Agency Review Comments

Project Name	Mt. States Pipe and Supply Site Development Plan
Applicant	Compass Surveying and Mapping, LLC
EA Number	EA18269
File Number	PPR2020
Project Manager	Lindsay Darden (lindsaydarden@elpasoco.com) (719) 520-6302
Status	Active
Created	9/26/2019 1:24:00 PM

ELECTRONIC STORAGE  
SITE DEVELOPMENT PLAN  
DETAILS SHEET  
SEPTEMBER 2020

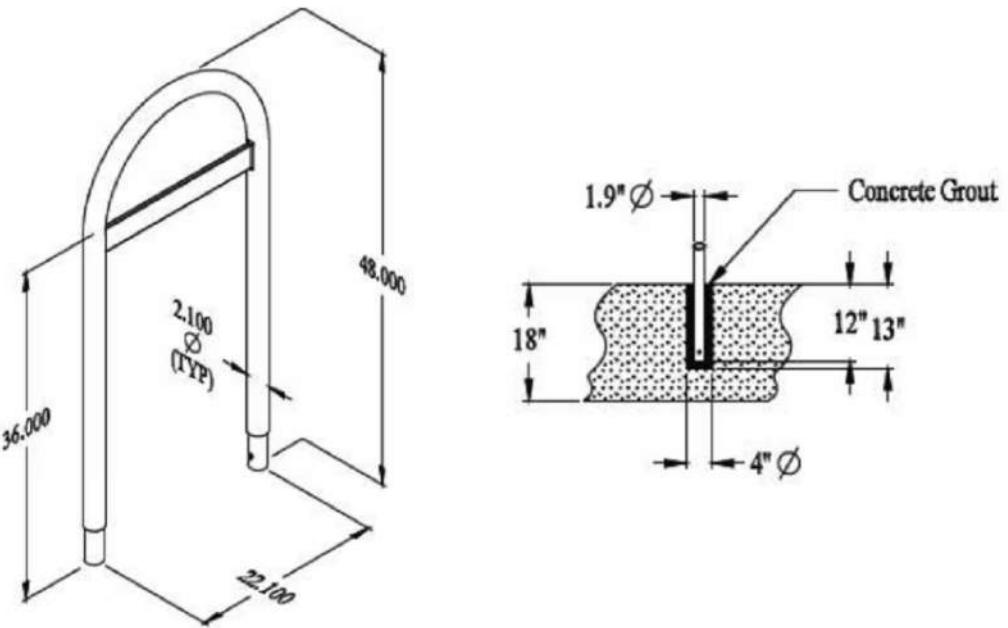
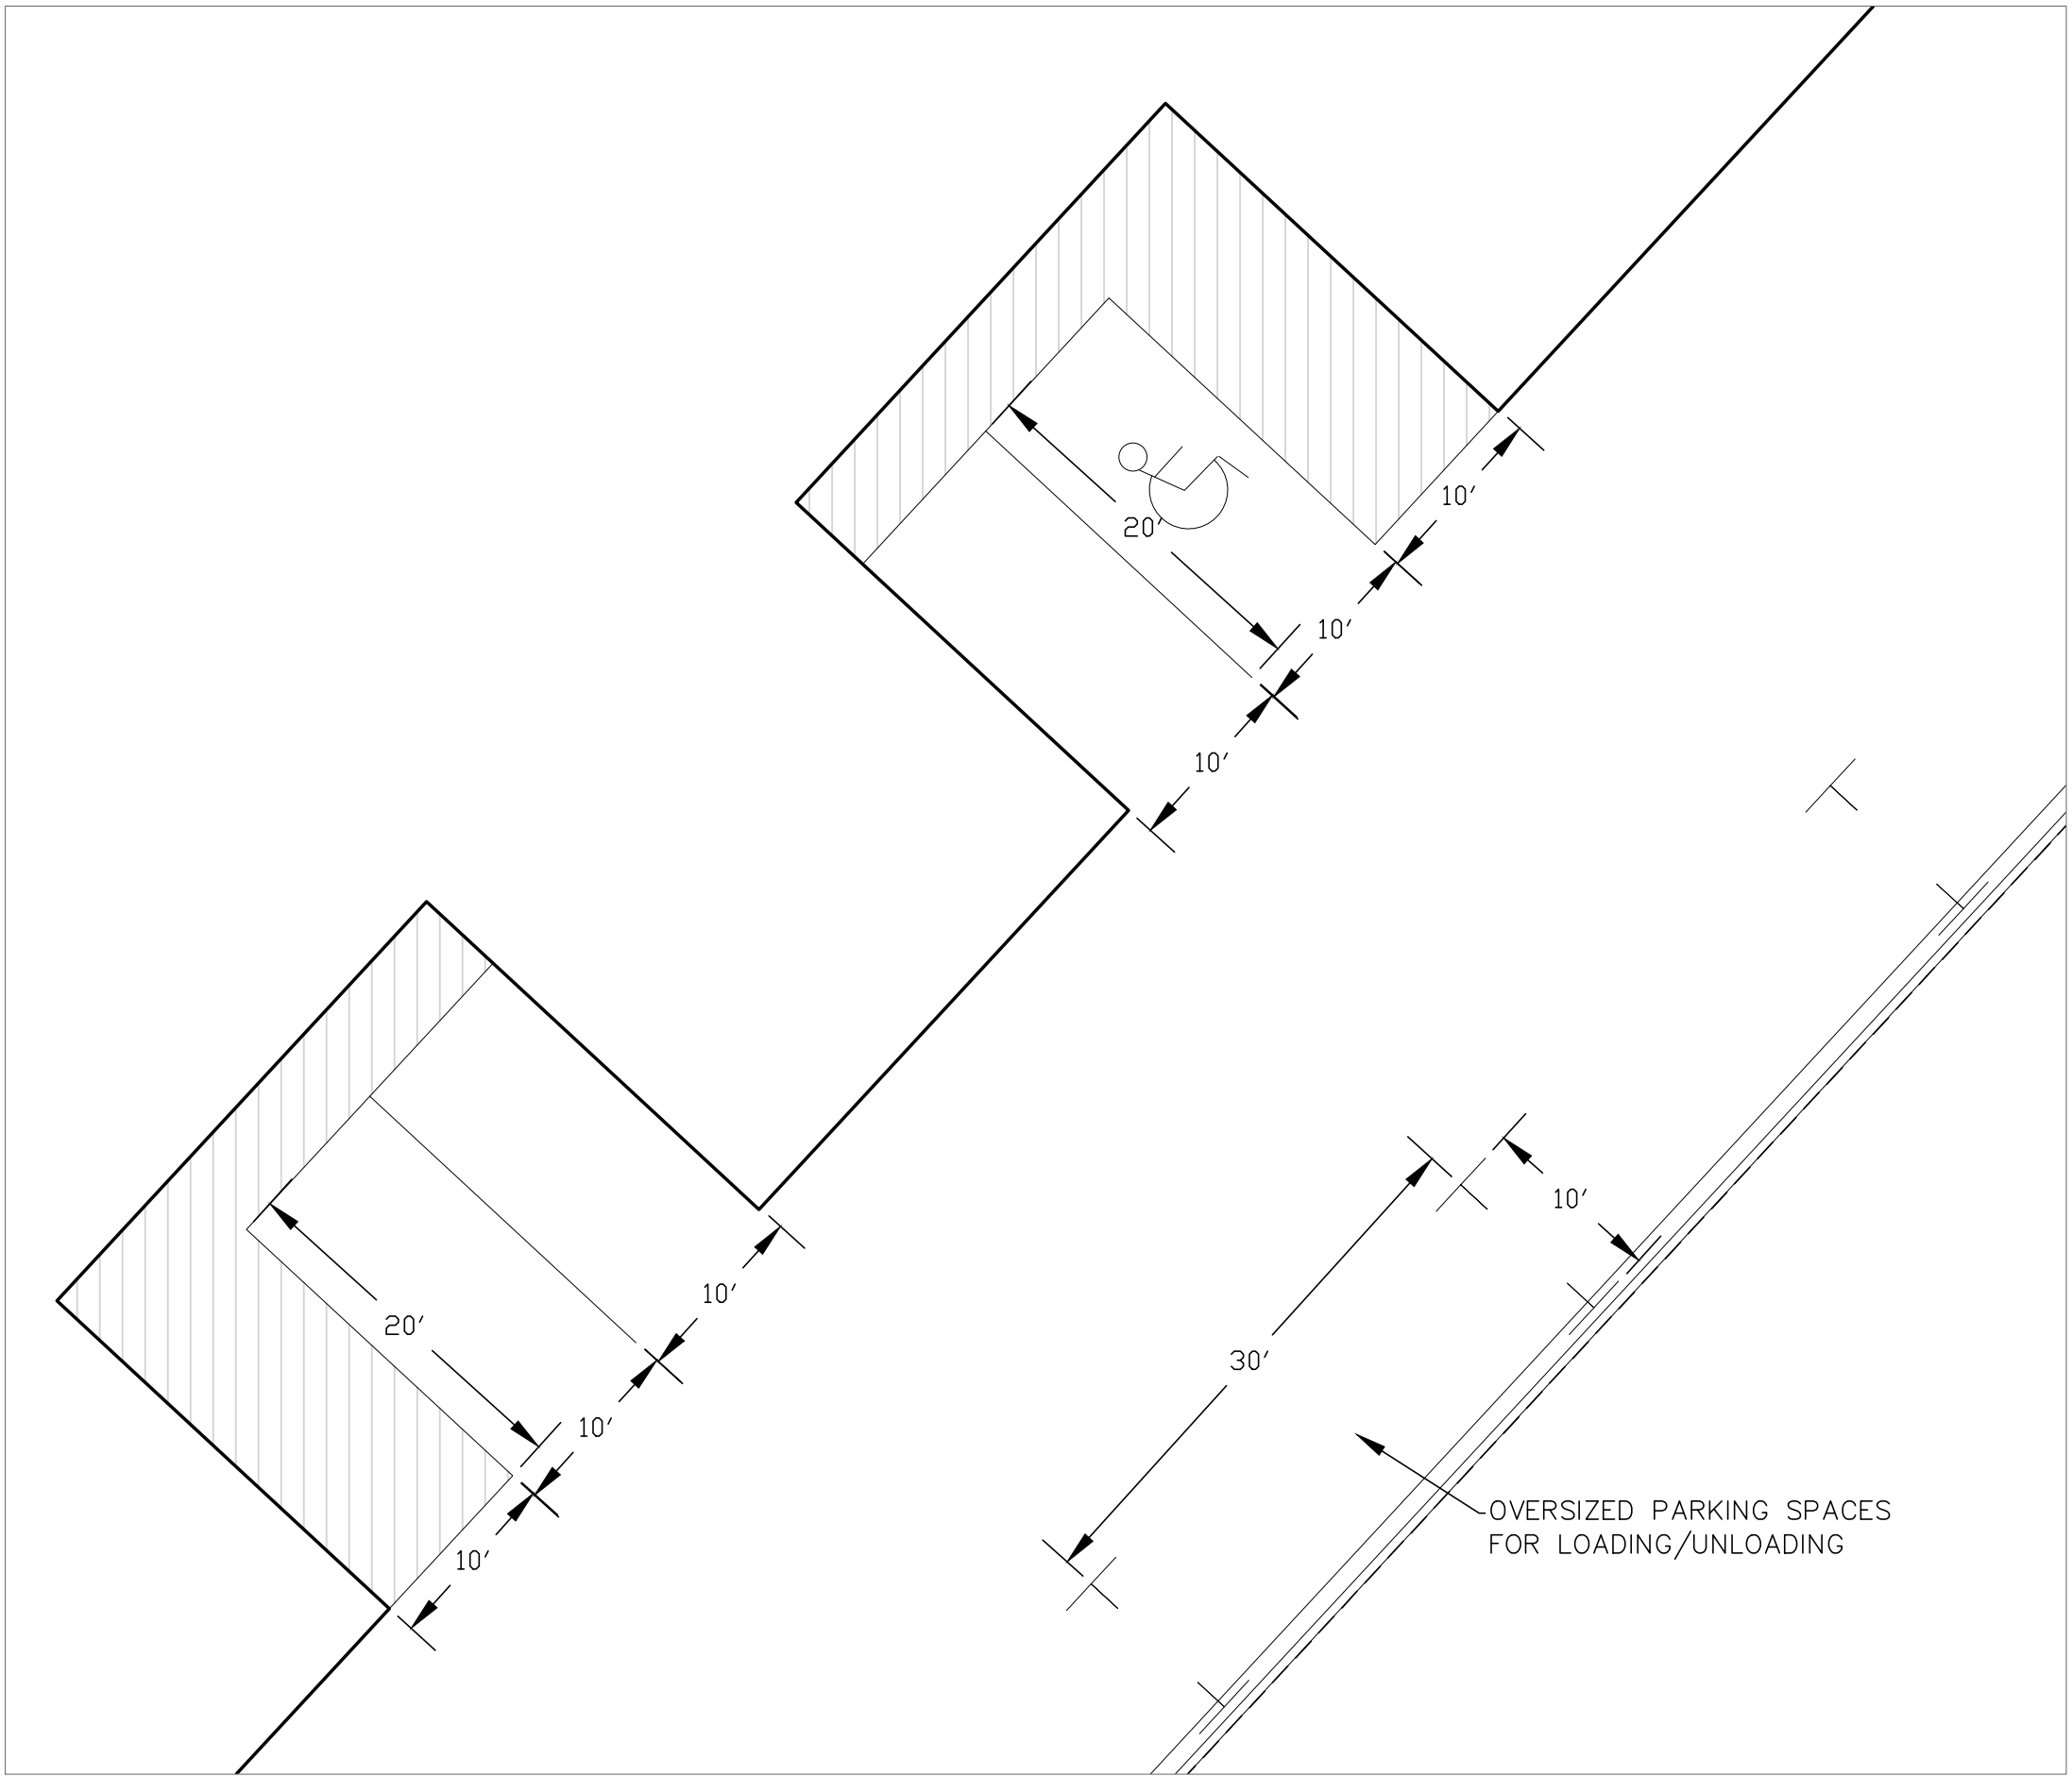
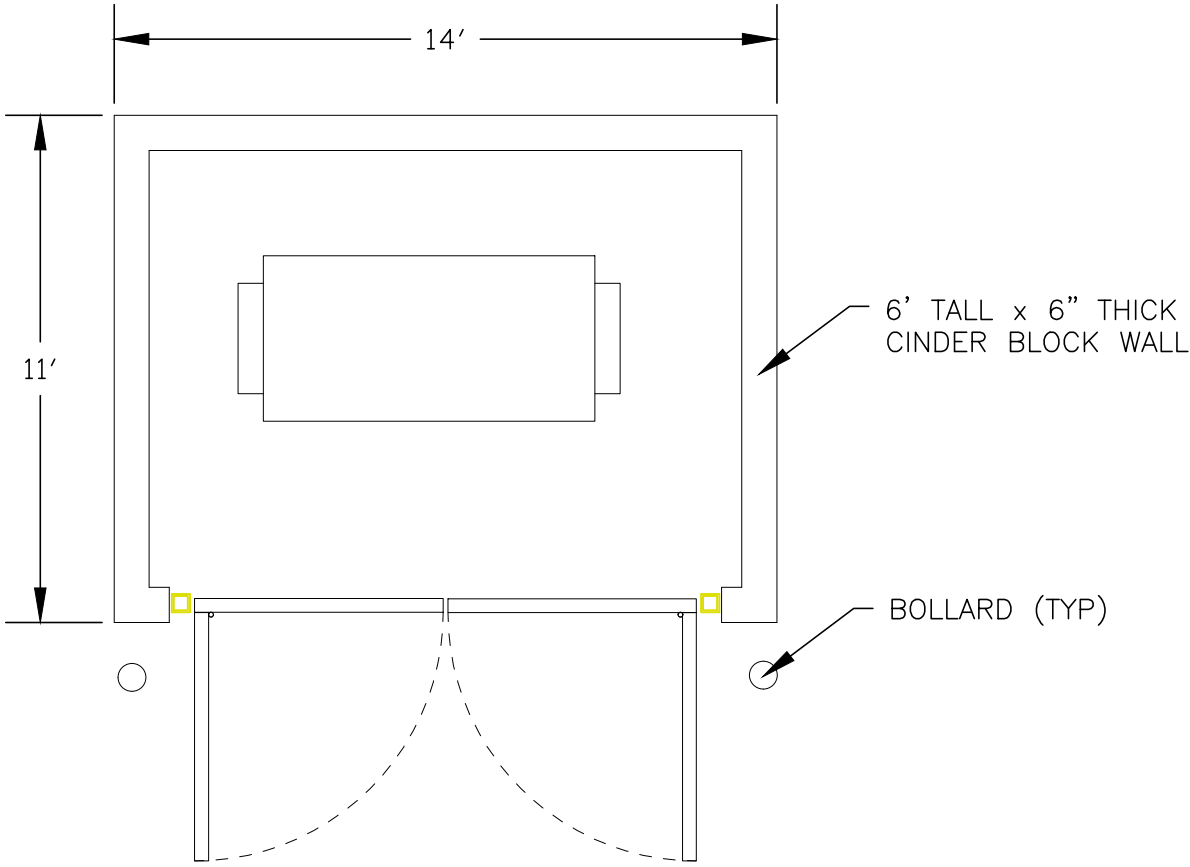
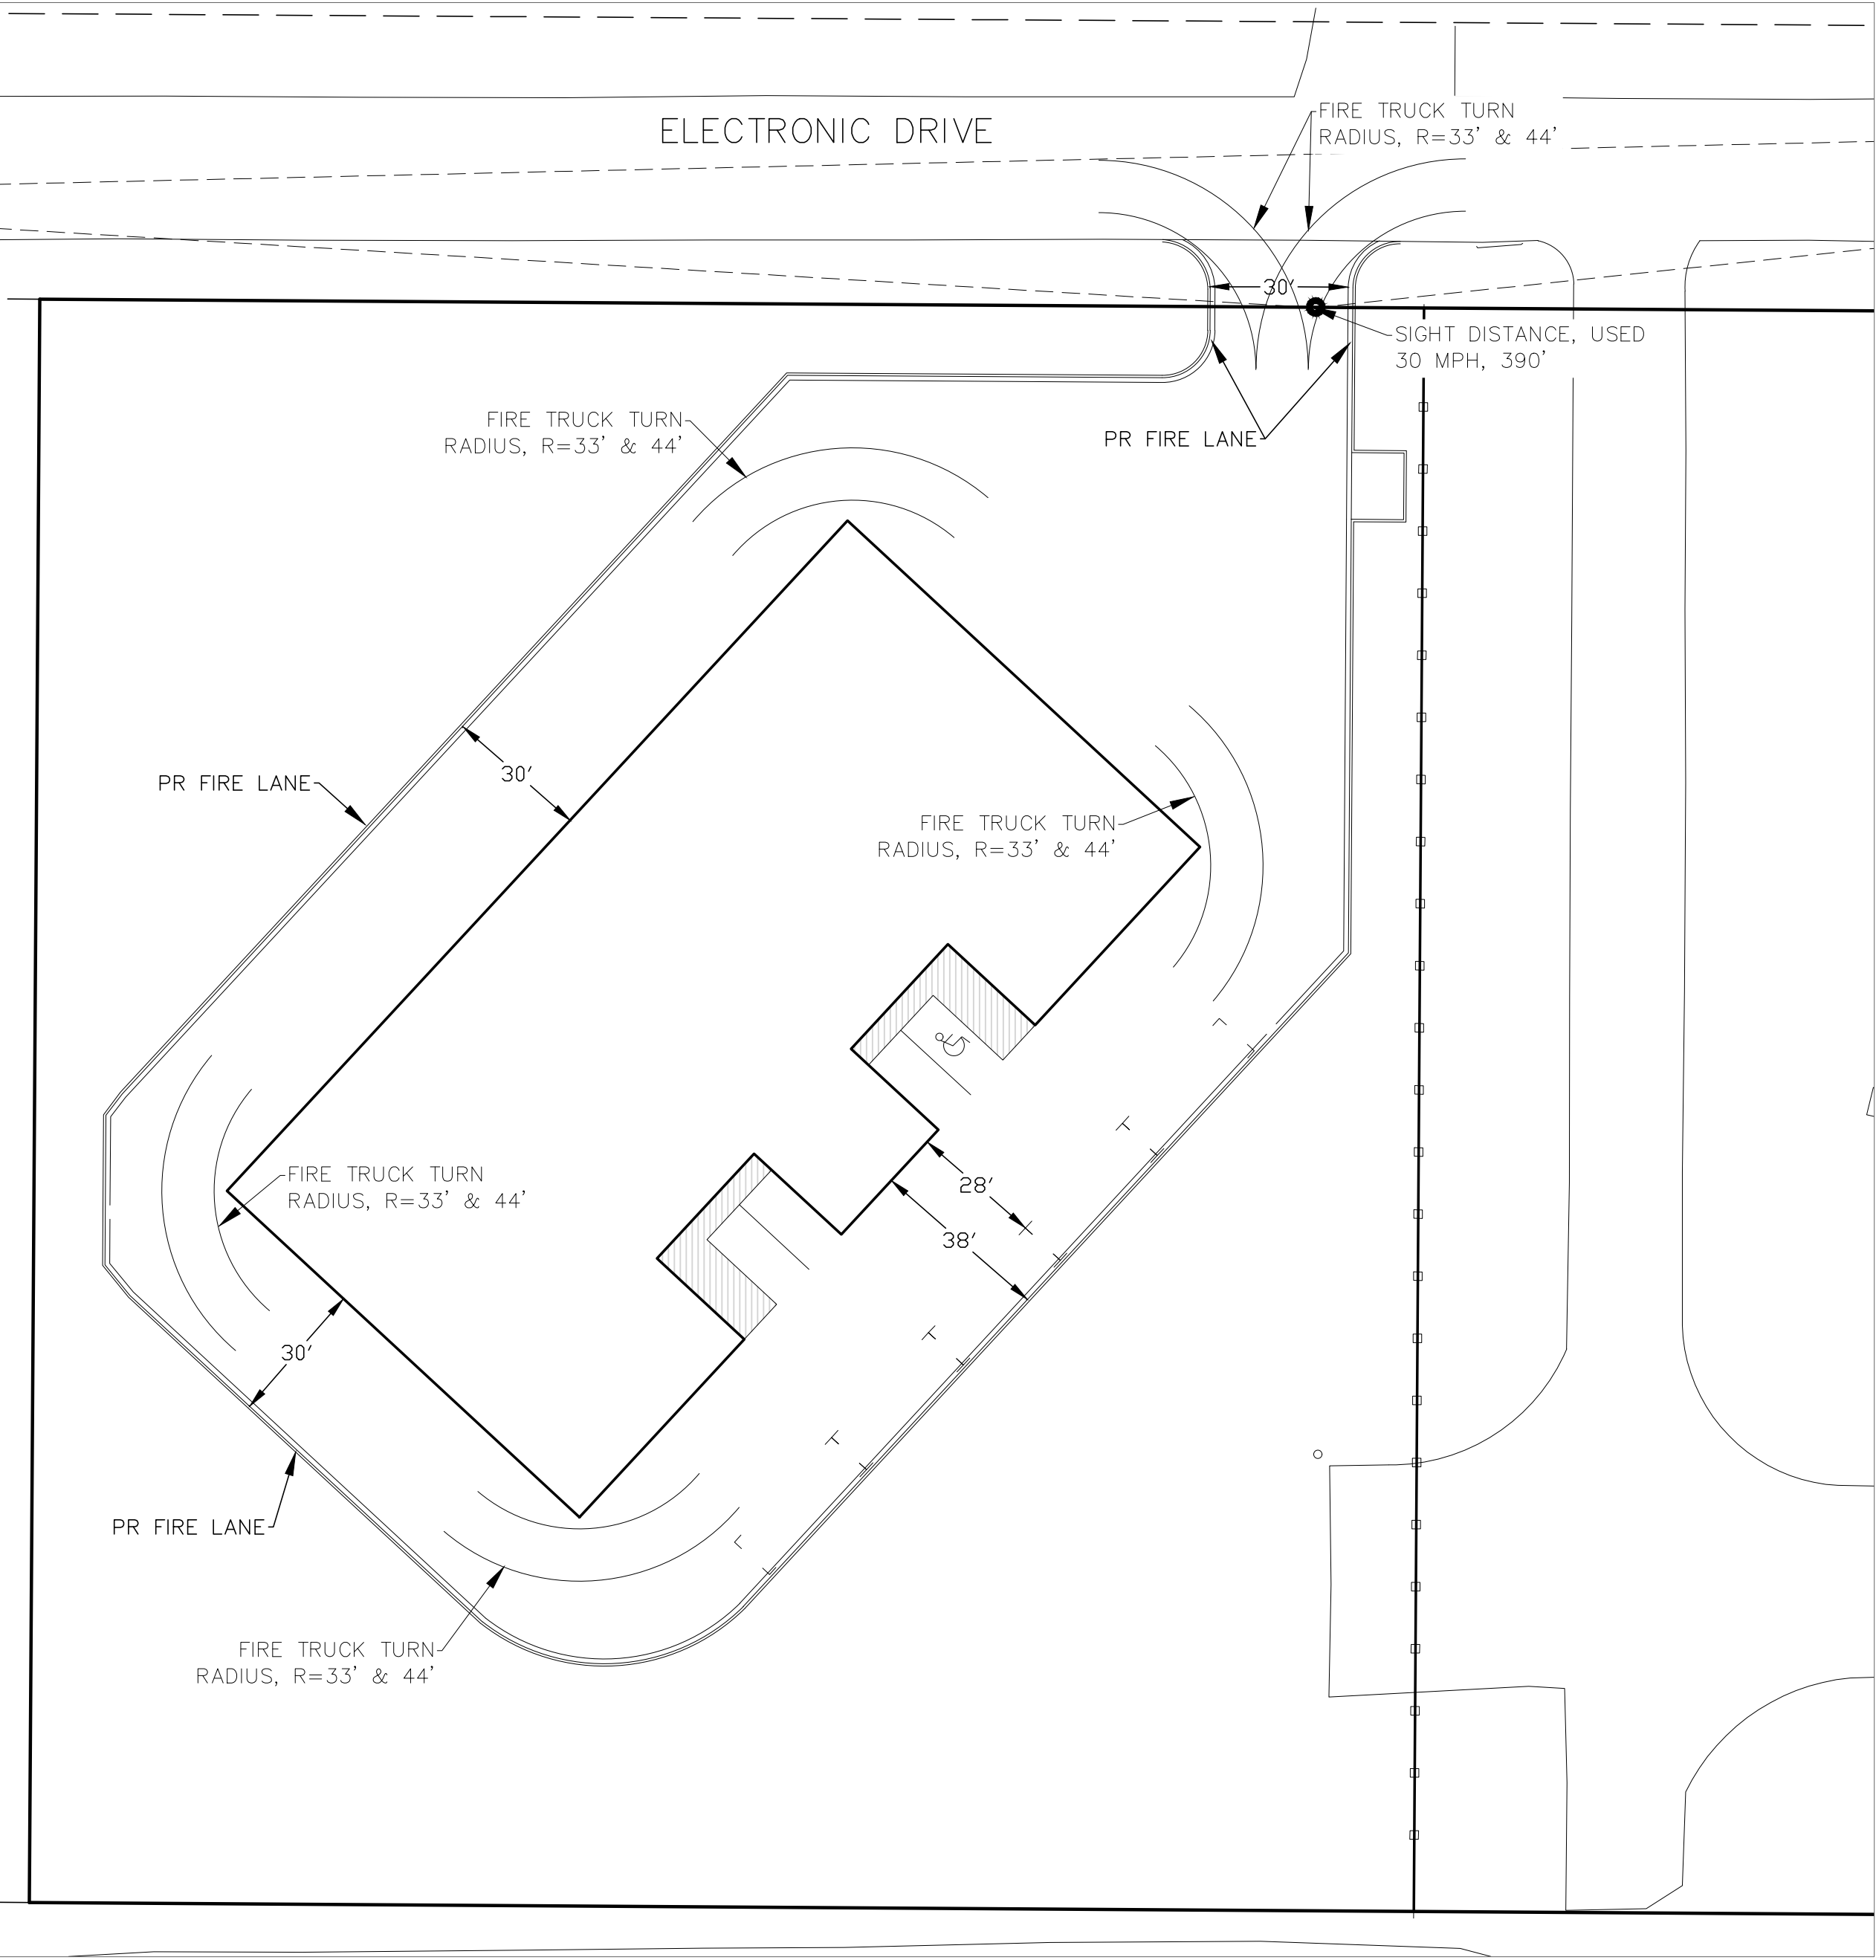
PCD Project Manager	Provide a detail for the 6' cedar fence.	10/7/2020 11:31:40 PM
PCD Project Manager	Provide an elevation view of the trash enclosure to demonstrate height. Label the material of the access gates. Will the enclosure be painted or otherwise treated to match the building?	Unknown on the painting. Since the County is requiring it be screened by landscaping, I don't know why they'd also paint it.
PCD Project Manager	The HC parking access aisle detail is missing a dimension for the width of the narrow access aisles in front of the parking spaces. Please dimension.	PM
PCD Project Manager	Please refer to the Bike Parking Design Standards of Land Development Code Section 6.2.5. It requires attachment to pavement and that bike parking facilities be at least 2 feet wide x 5.5 feet long. Based on the site plan, it doesn't appear the bike rack provides that.	10/7/2020 11:21:45 PM
